LANDSCAPING SCHEME 1:200@A2

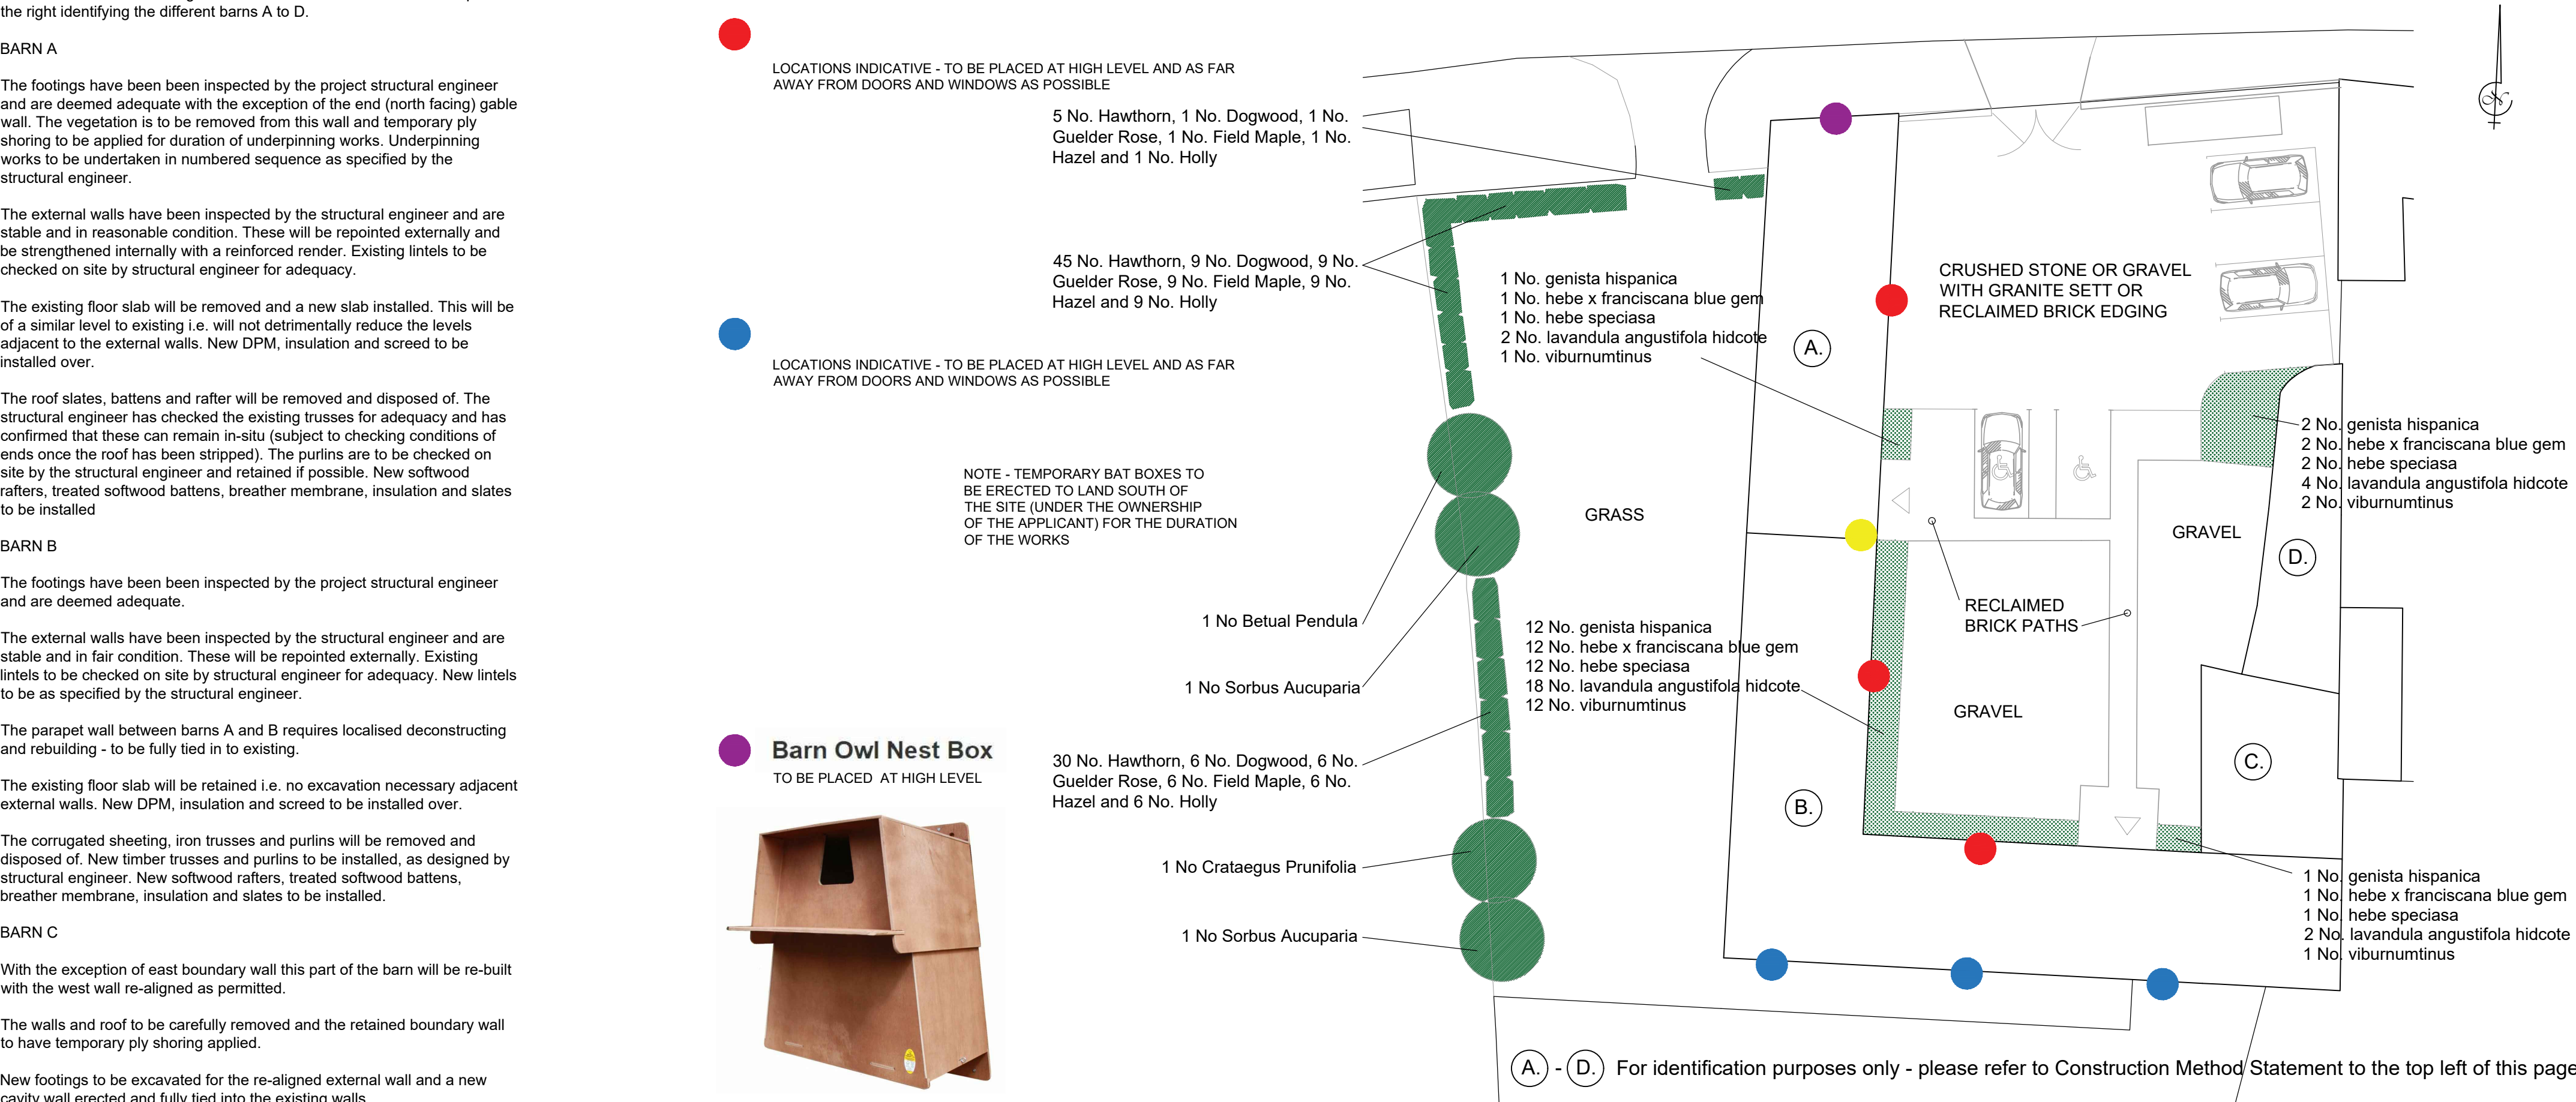
With regard to the landscaping condition (13) the application requires further information to be shown comprising the following:

- Actual quantities to be provided in location for the shrubs and hedging proposed and which trees going where for the trees indicated, shown also on the plan.
- Please can this information be submitted in plan form. This can be hand annotated onto the plan 1169/Figure 1 Rev 2.
- I would appreciate receipt within the next 10 days.
